**From:** Thomas Whitfield <thomas@georgiangroup.org.uk>  
**Sent:** 24 September 2025 08:01  
**To:** DC Admin  
**Cc:** Conservation Design  
**Subject:** Case 2025/92388 - Red House Museum, 281 Oxford Road, Gomersal

Thank you for notifying The Georgian Group of application 2025/92388 for a scheme of works to convert The Red House Museum, 281 Oxford Road, Gomersal from 3no. residential units. The Group registers no objection in principle to the conversion however we raise the following concerns with the proposed scheme of works.

The application is for a scheme of internal and external works to convert the house to form 2no. residential units and the barn to 1no. residential unit.

Drawing title
**Red House
Ground Floor Plan as Proposed**

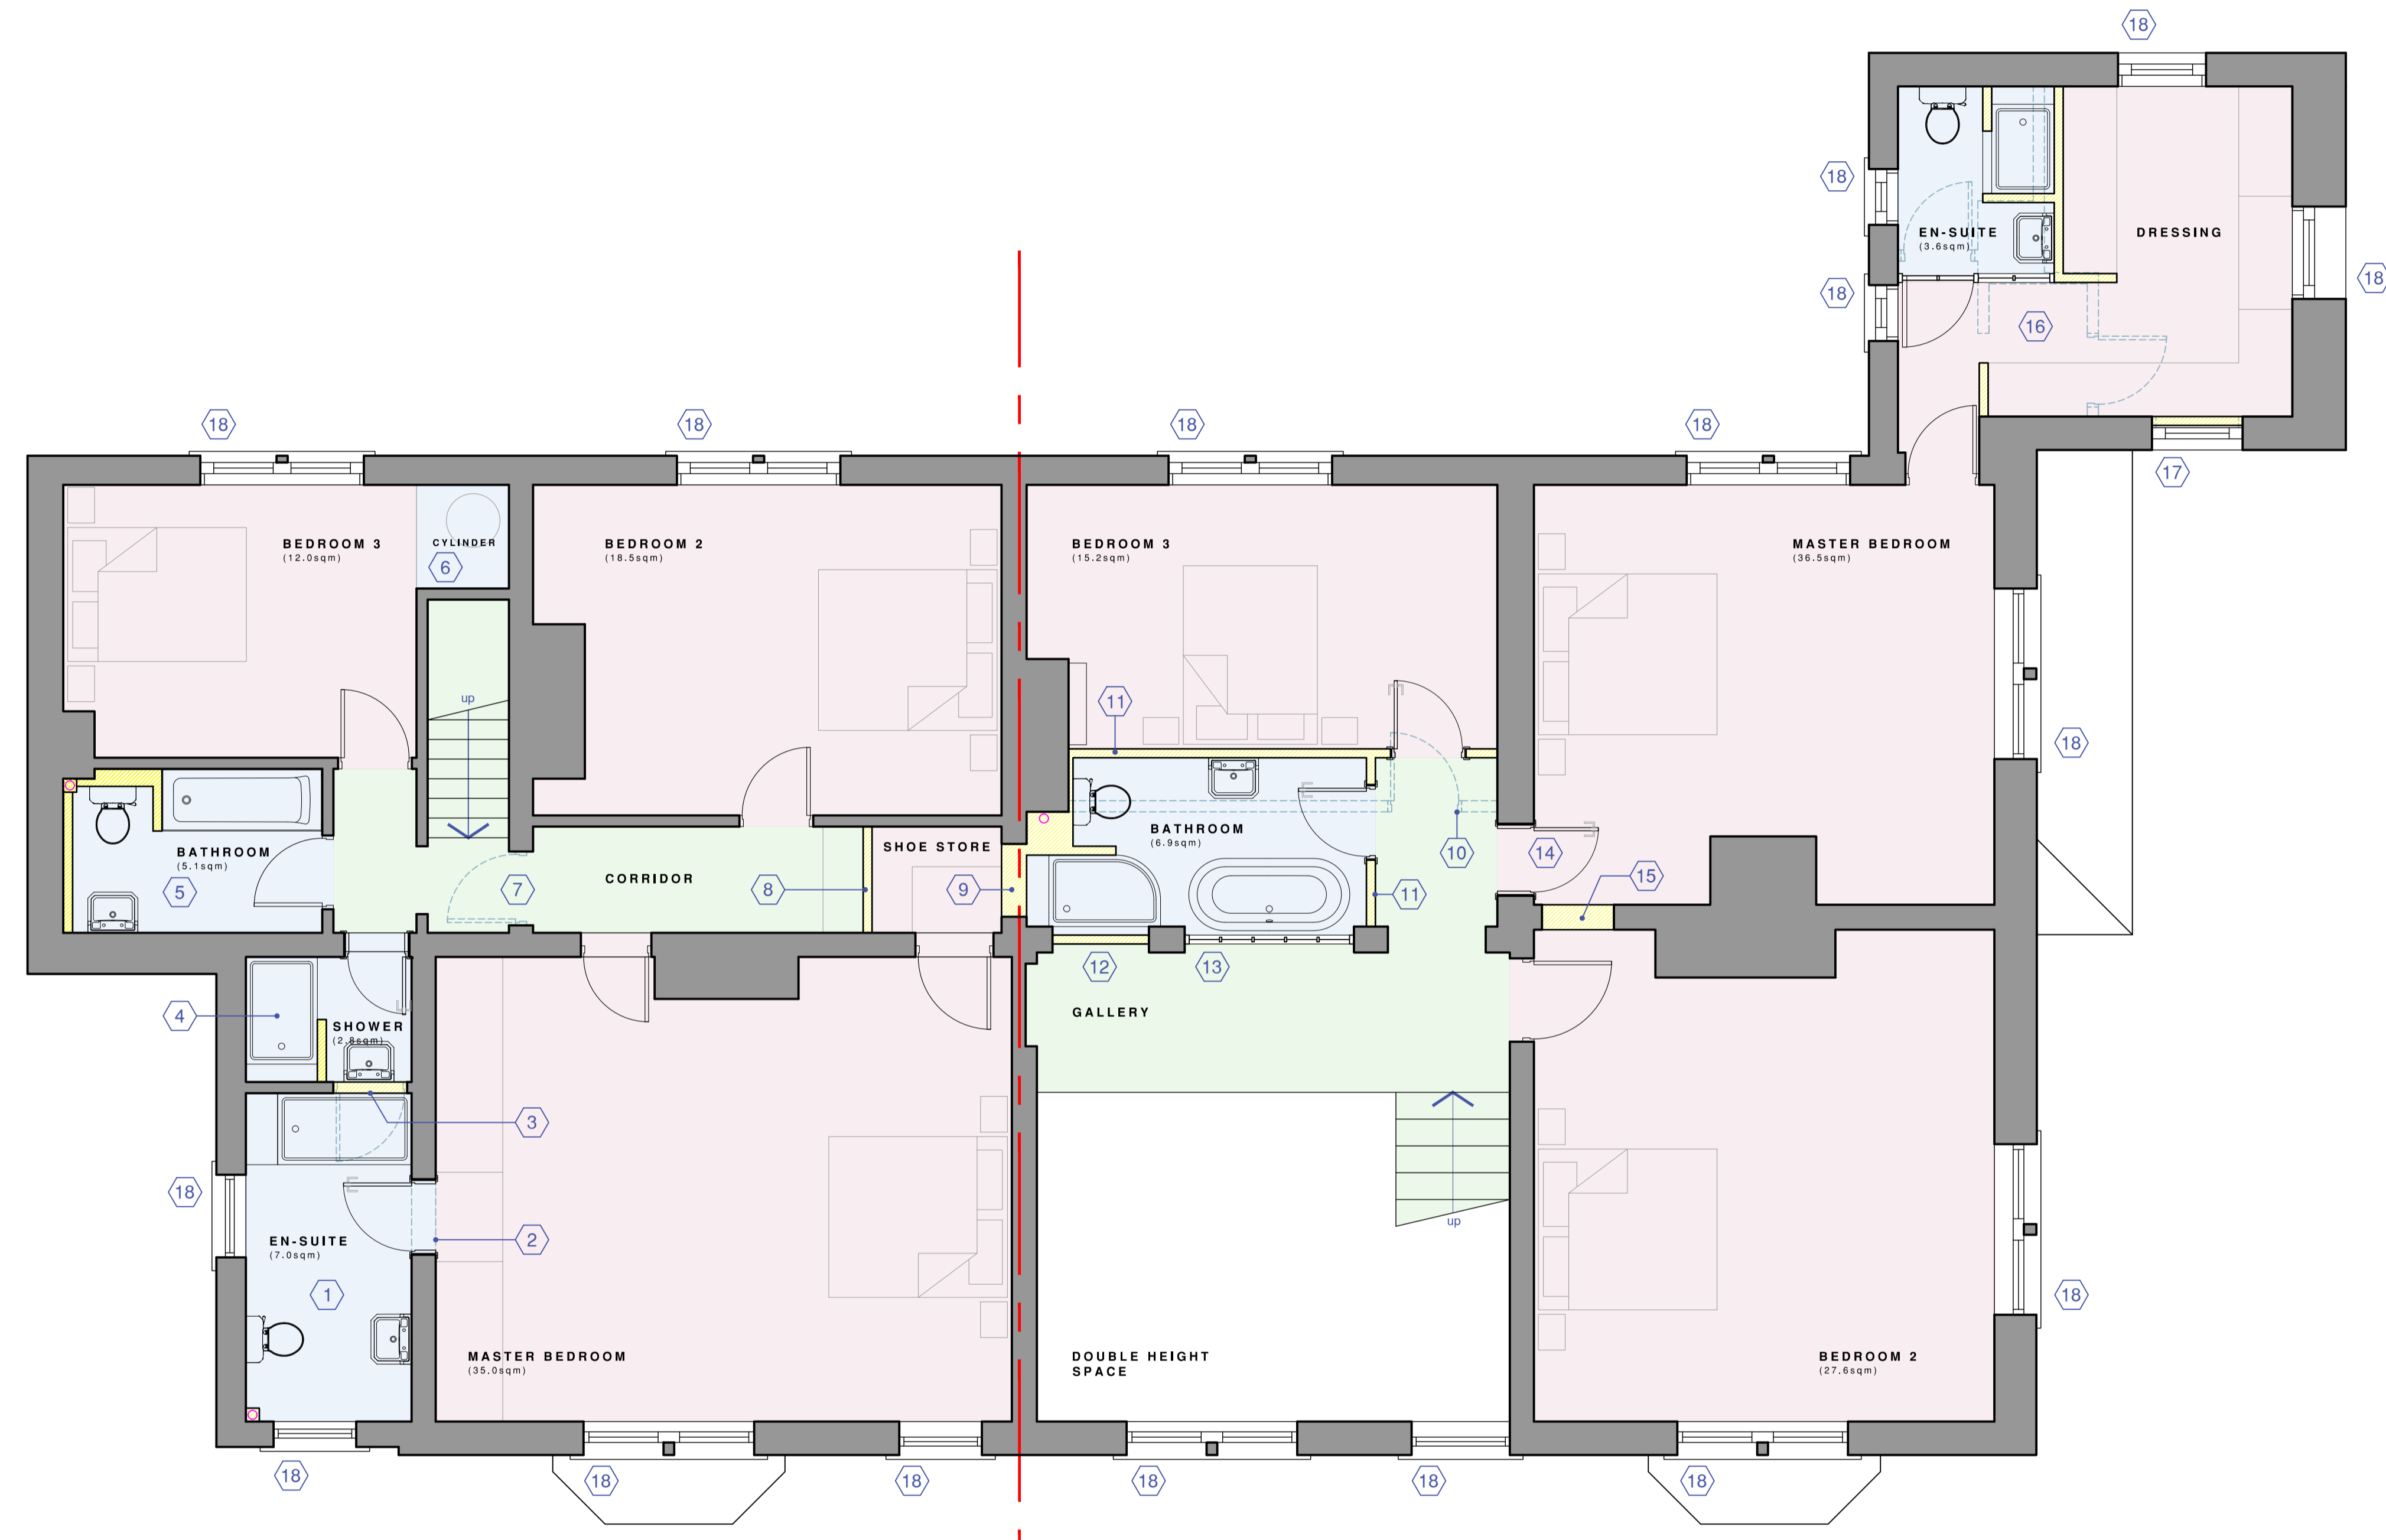
The Group queries the need for the proposed lobbies/corridors at ground floor labelled Items 4 and 11 on the as proposed plans. We advise that these erode the historic planform of the building, weakening legibility of historic access patterns and room volumes. We can find no clear or convincing justification for these works

under the requirements of NPPF (2024) paragraph 213 and we consequently recommend that they are deleted from the application.

The Group likewise queries the need for, and proposed location of the WC/cloak room (item 13). We recommend that subdividing the room and forming a new opening to access the WC and Cloakroom would cause harm through loss of historic fabric from a probable primary phase wall and would further erode the already altered planform and room volume of the dining room.

The Group registers some concern with the proposal to form a family bathroom by introducing a stud partition across the middle of a probable primary phase chimneybreast with later fireplace (Item 11). We advise that we can find no assessment of the significance of the room in the applicant's heritage assessment and likewise no meaningful discussion of the impacts of this element of works in the applicant's heritage impact assessment.

We advise that we are consequently unclear whether the existing fireplace is of any historic significance and we accordingly draw attention to the requirements of NPPF paragraphs 207 and 208.

We advise that introducing stud partitions across the middle of chimneybreasts and fireplaces invariably causes harm eroding the legibility of historic room volumes and planform, and diluting the historic character of rooms. Whilst we recognise that the room has already been partitioned to create a corridor with a stud wall of uncertain date (presumed modern in the HIA), this adjoins the corner of the existing chimneybreast, presumably leaving the fireplace clear in a more sympathetic manner than the partition proposed.

We recommend that further discussion of the significance of the chimneybreast, fireplace and existing room volume are discussed in greater detail with an heritage impact assessment submitted.
